Application no: **3/2021/0418**

Address: **1 Dorset Drive Clitheroe BB7 2BQ**

Proposal: **Proposed boundary treatments to dwelling. Resubmission of 3/2020/1049.**

The Local Highway Authority have viewed the plans and highway related documents and have the following comments to make:

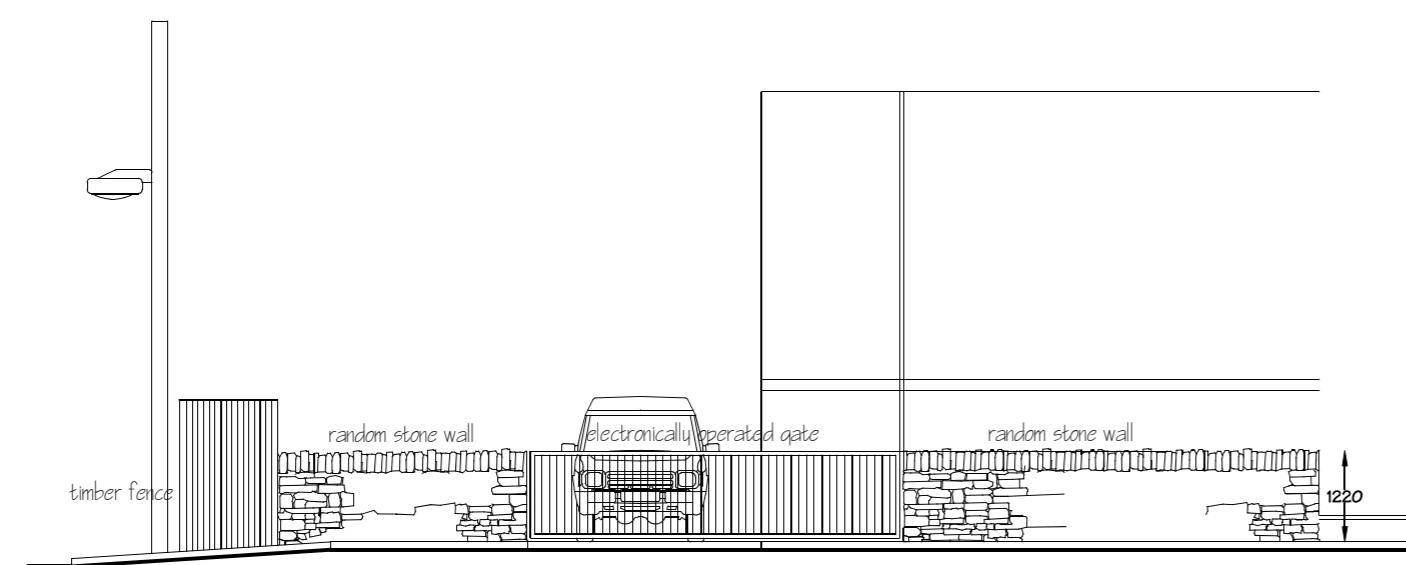
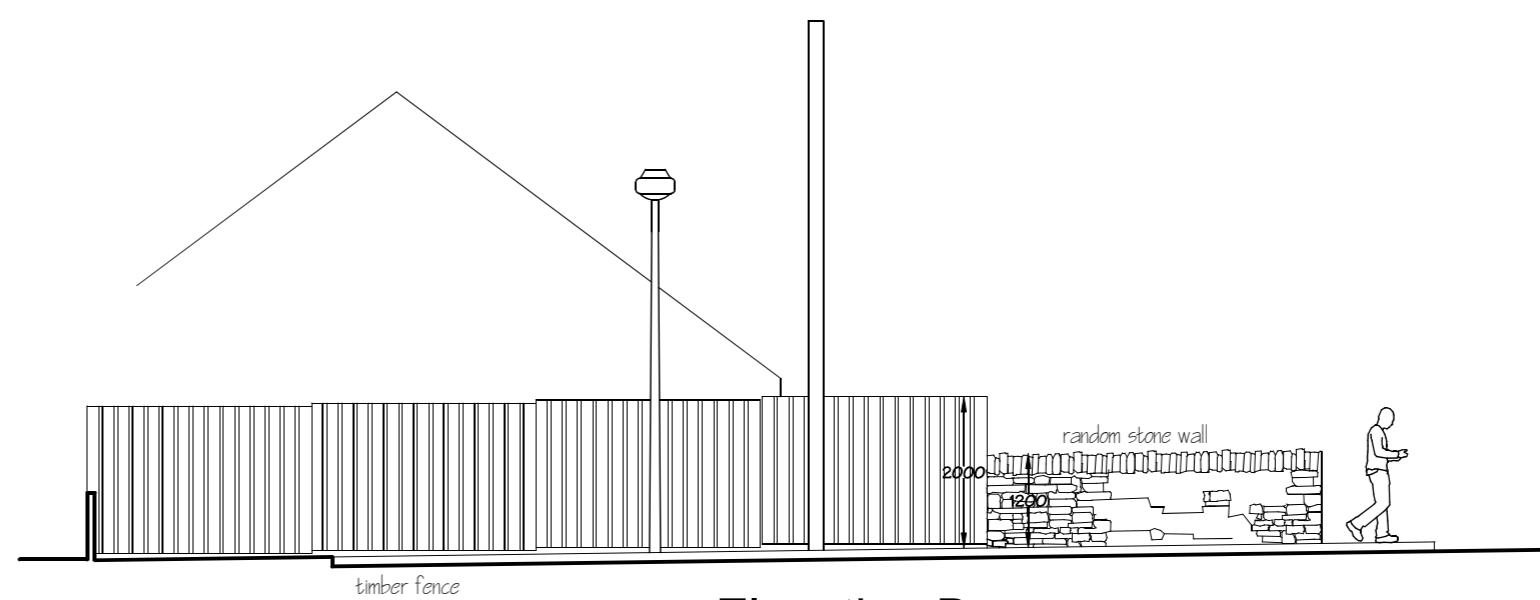
The LHA have reviewed the supporting information and understand that the gated access shown on PD drawing number 1201-1-02 titled "Proposed Site Plan and Elevations" will still be set back a distance of 1.88m from the footway.

The LHA will remind the Applicant that a gated access serving a single dwelling is required to be set back a distance of 5m behind the footway, to allow for vehicles to operate the gate and not obstruct the highway.

The LHA will instead require the gate to be setback a minimum distance of 3m from the footway and this should be shown on a revised plan.
